Subject: 23314 Wicks Farm - Drainage

Further to your comments as follows in *blue* below please find attached the updated drawings and I confirm the following after your comments:

TITLE
Proposed Levels and Drainage
Sheet 1 of 6

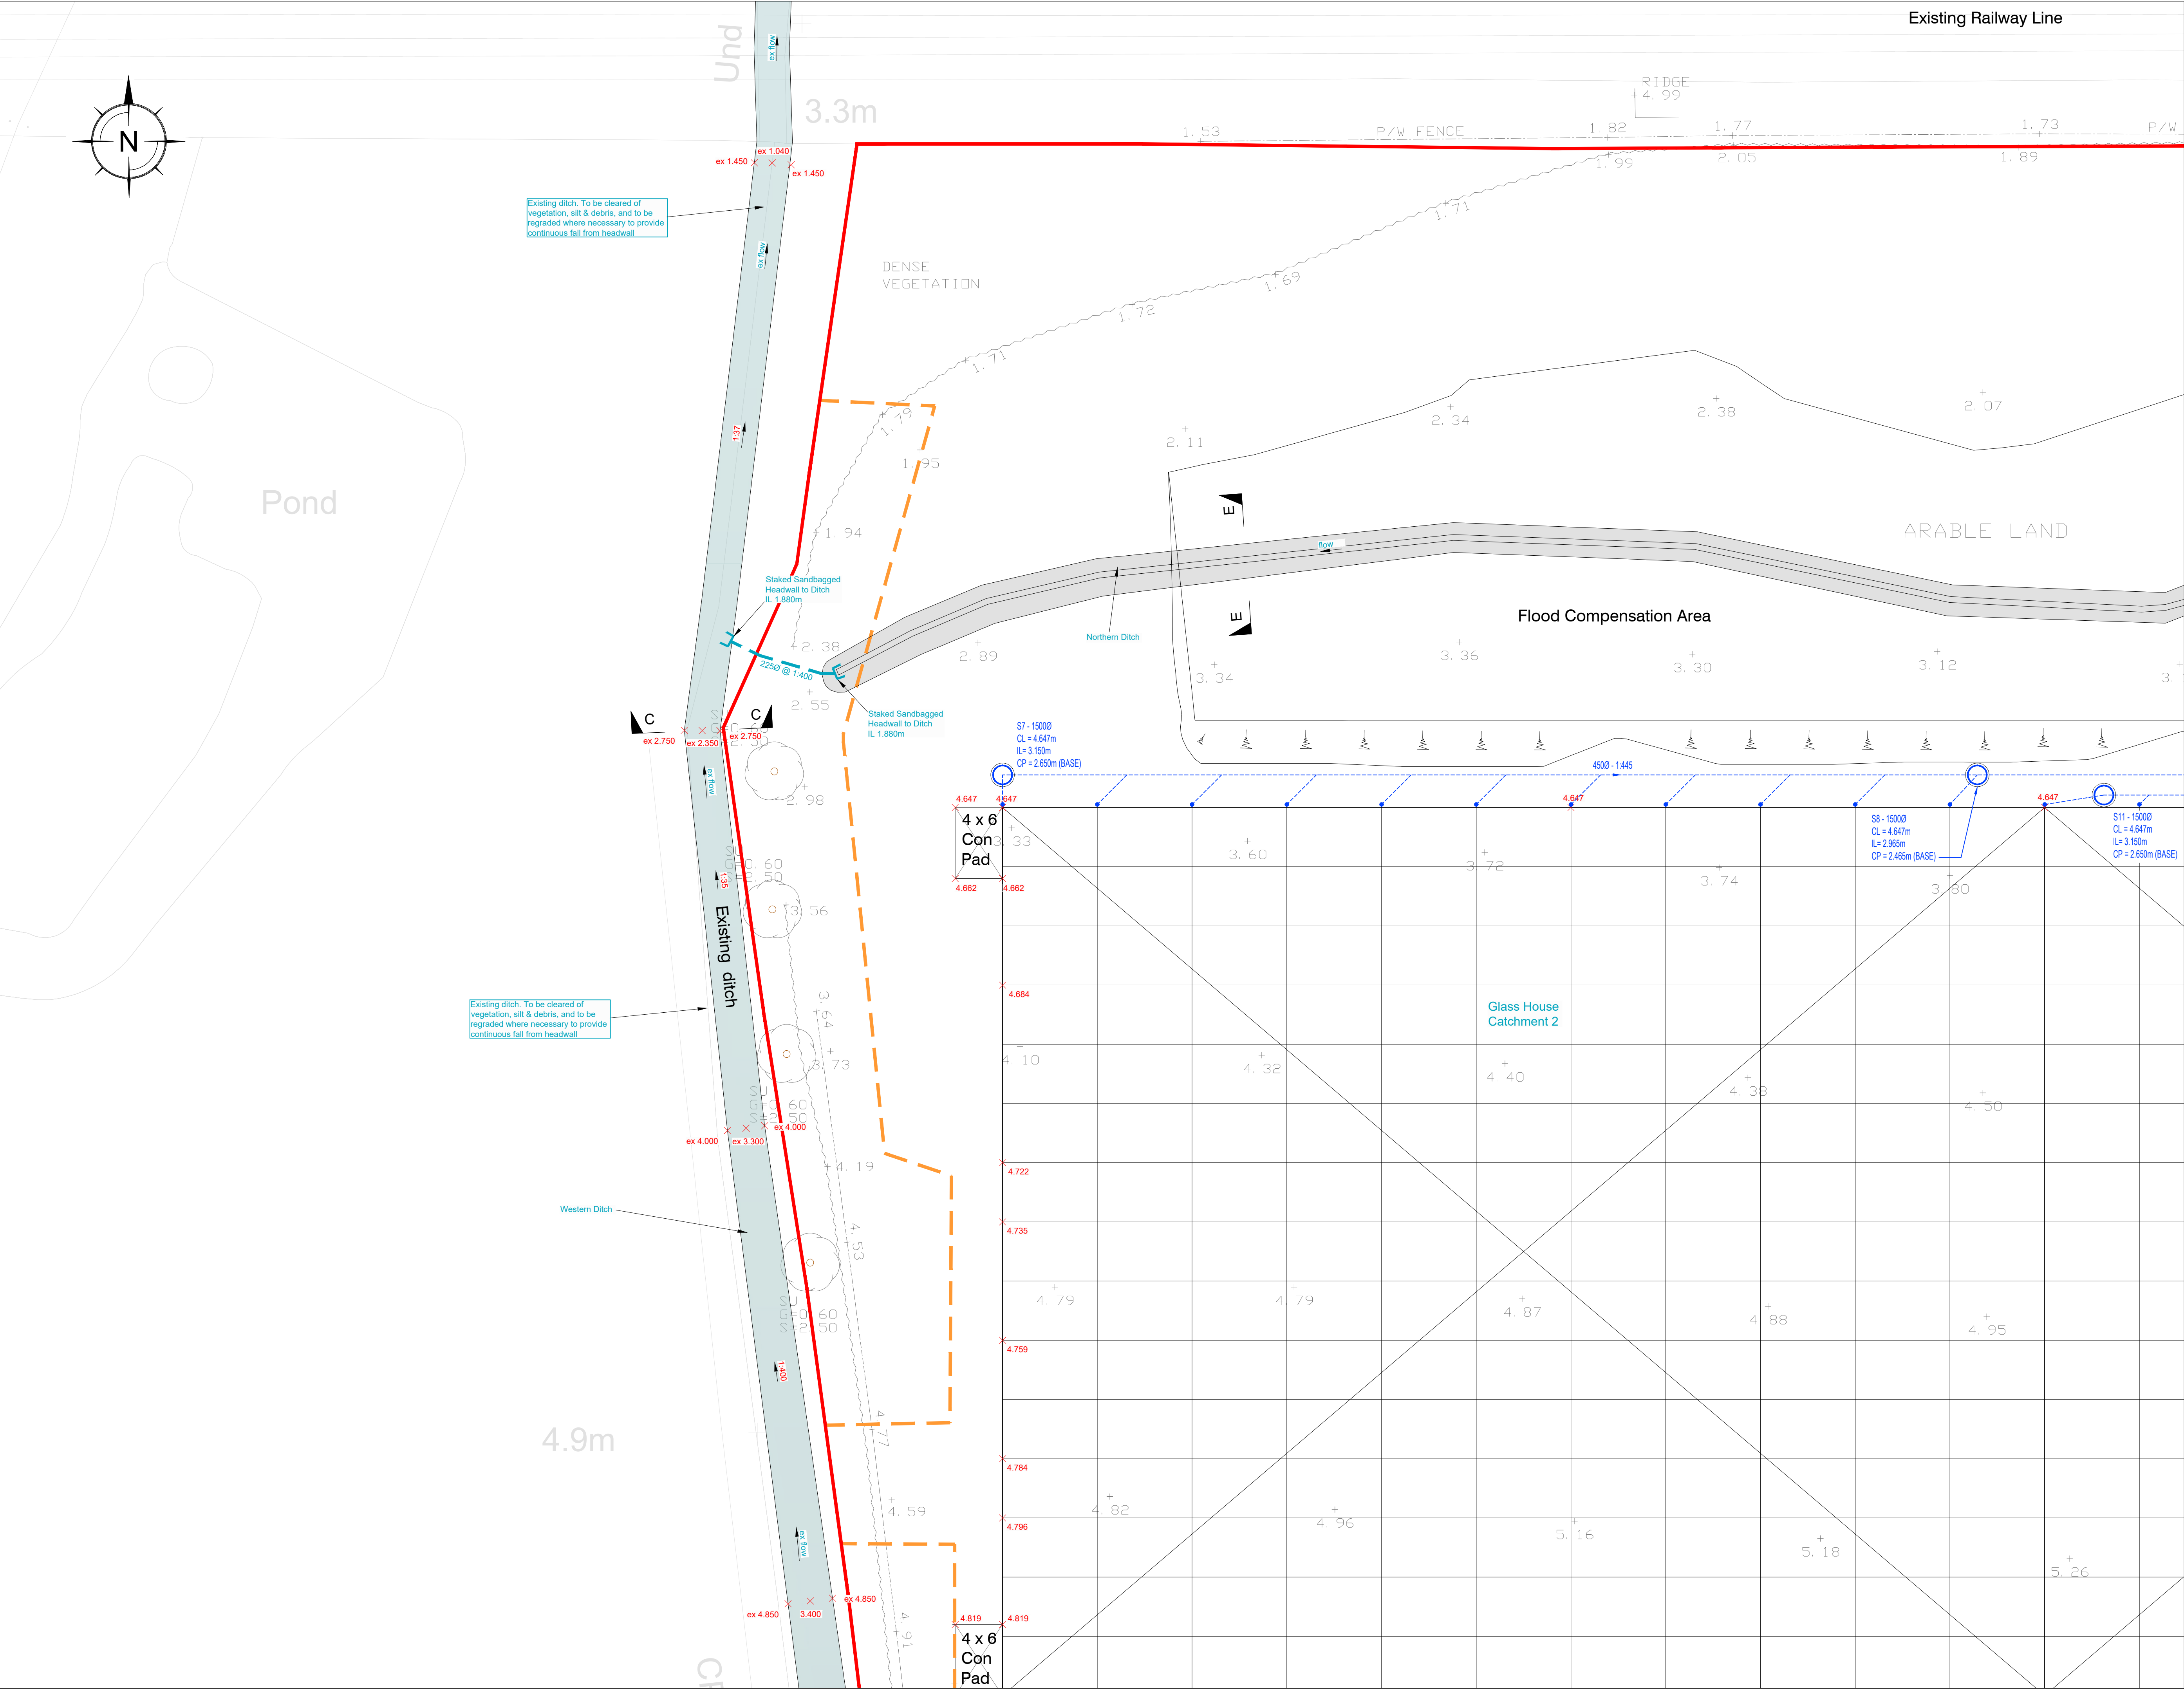
Regarding item 7 – the outlet invert and pipework downstream (+ ditch bed?) will need to be adjusted to suit the swale bed if you are proposed to adjust the bed level to 3.800 at that end or else storage will be lost ie. pipe invert would be 325mm above swale bed meaning there could be standing water in the base occupying allowable storage and may also produce a mosquito issue due to standing water. Revised construction details required for headwall/trash screen. Noted the bed will be adjusted to the outfall levels as indicated on the drawings, we have updated the pipe size and headwall and grill details as required for the 150mm diameter pipe installed.

CLIENT	DPS Limited		
PROJECT	Wicks Farm Ford		
TITLE	Proposed Levels and Drainage Sheet 2 of 6		
DRAWN	DATE	PROJECT NO.	
PR	Feb 2020		23314
ENGINEER	CHECKED	DWG. No.	REV.
SB		22	H
SCALE			
1:250 @ A1

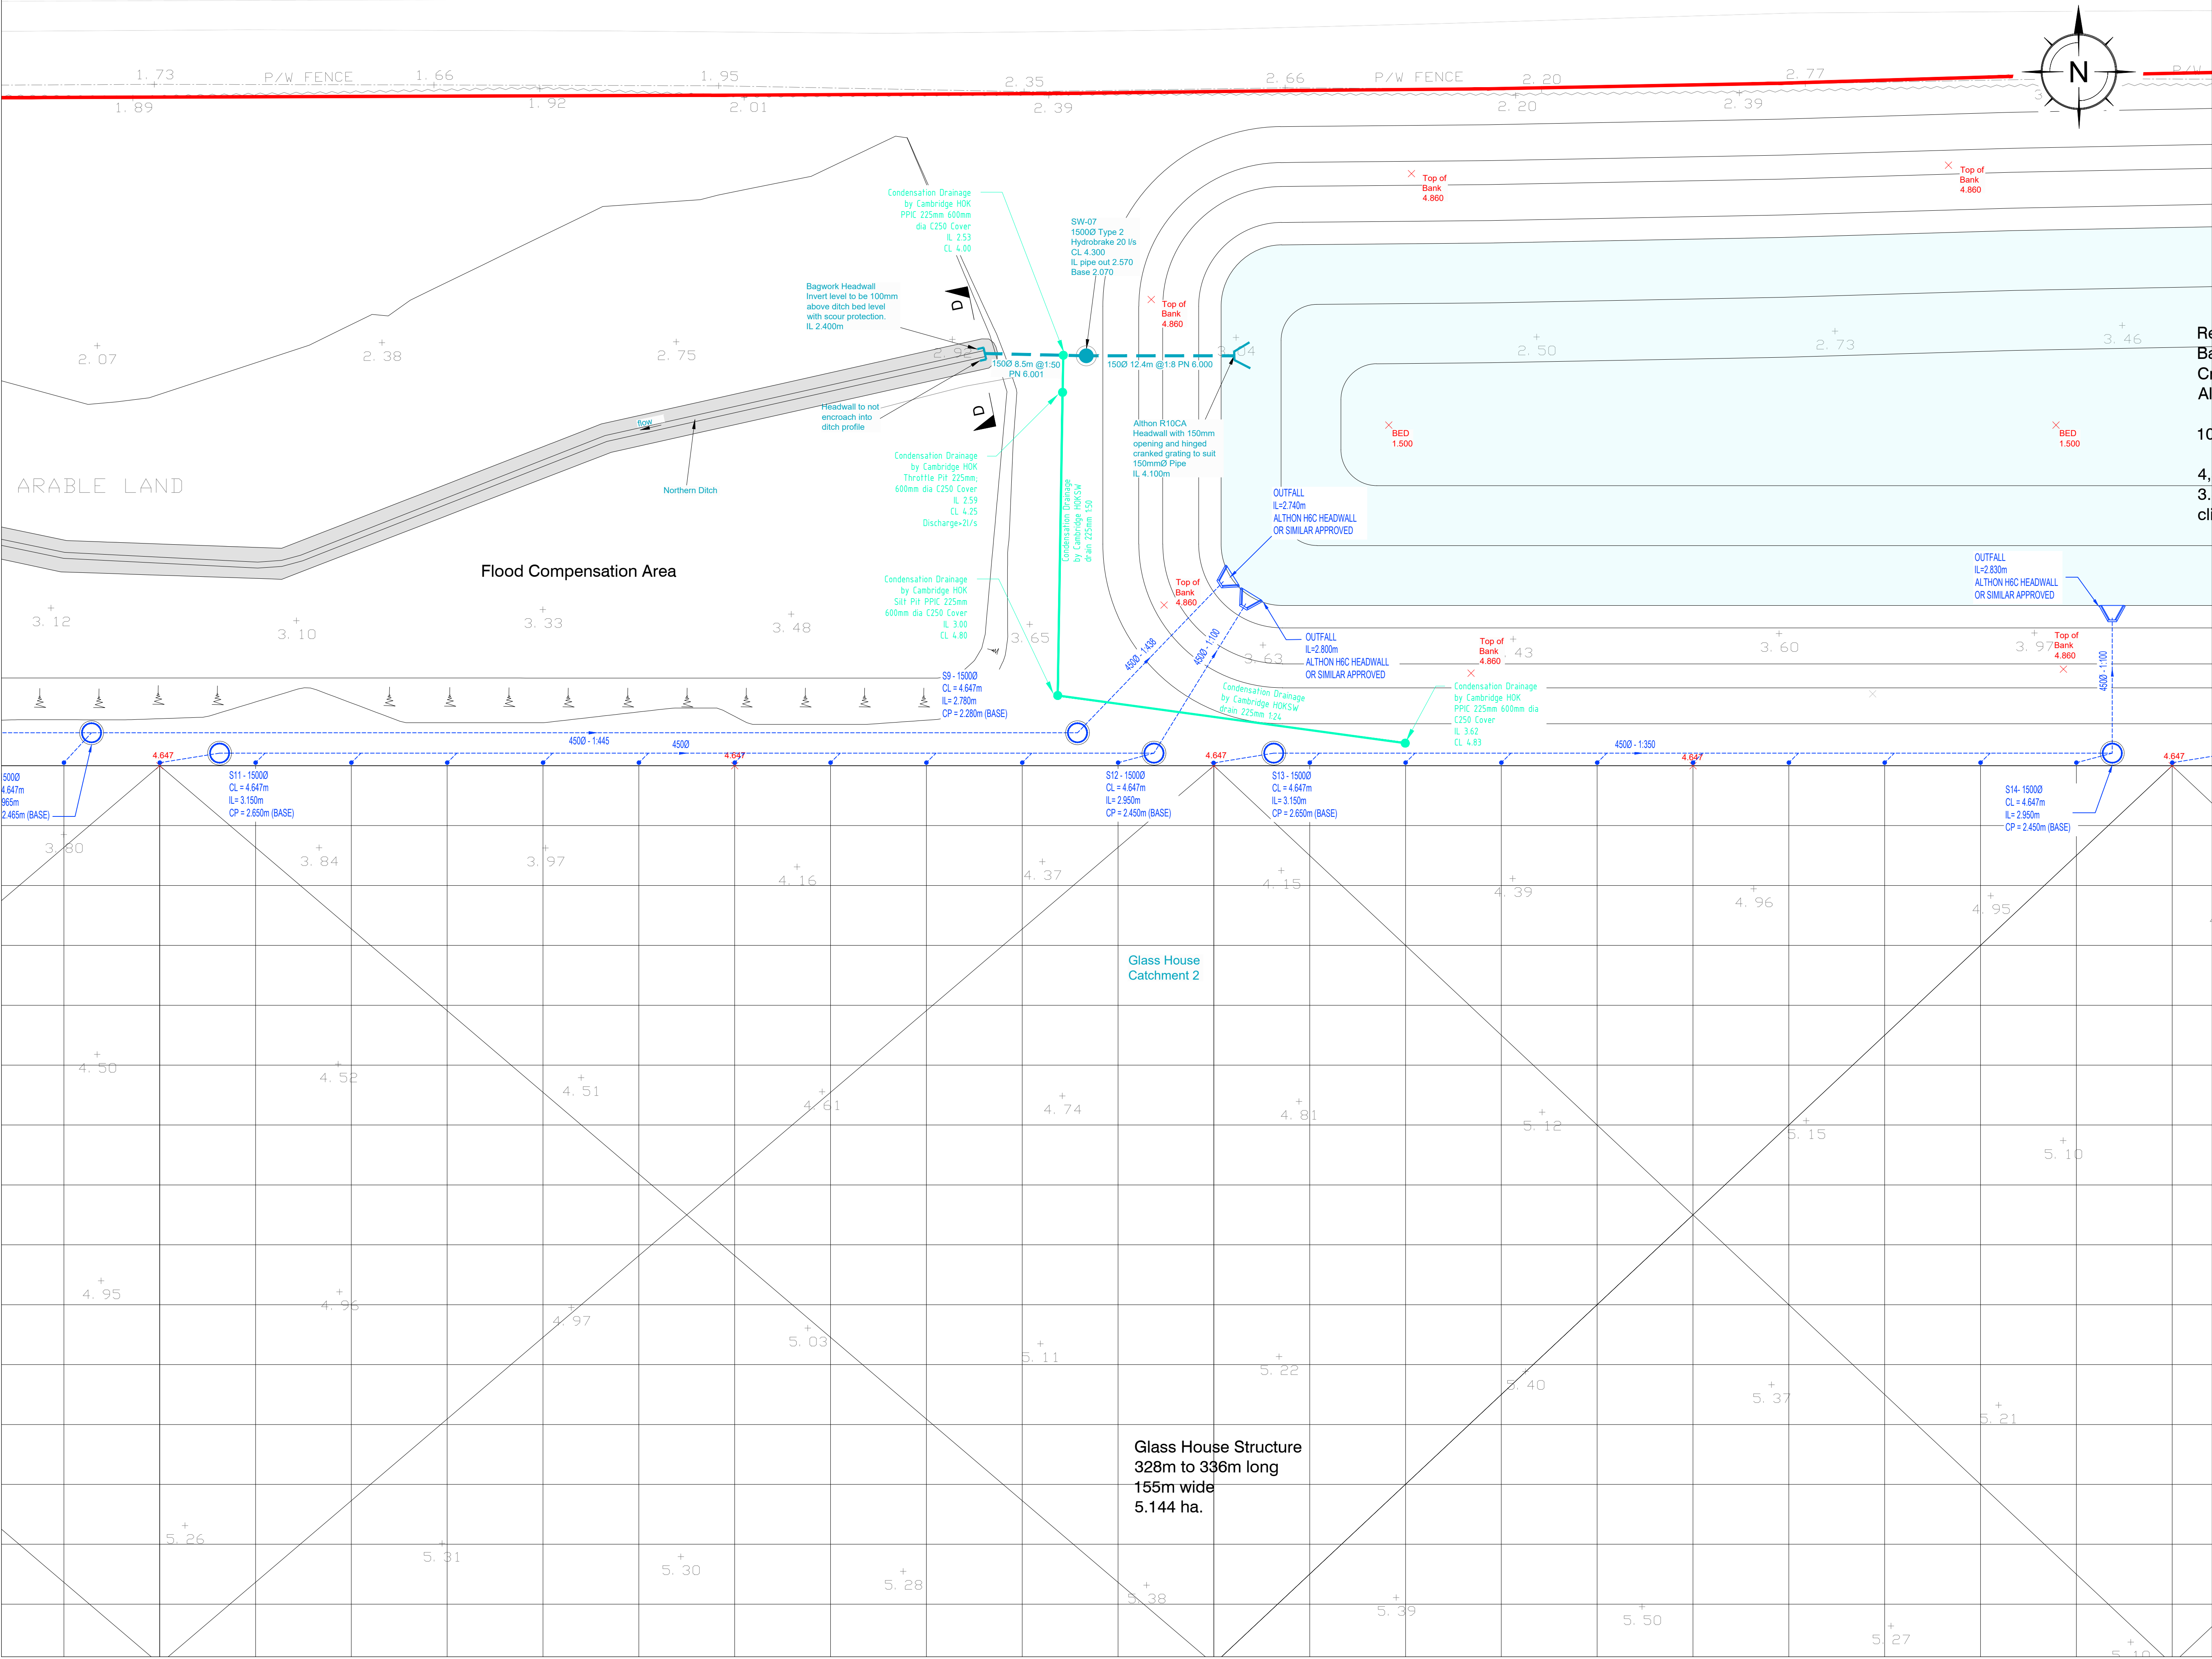
Item 11 – provide construction details of the flow control chamber and re-route the western condensation drain to improve the connection angle, irrespective of anticipated flows. We have indicated the condensate drain onto drawing 22H and adjusted the connection remove the oblique connection.
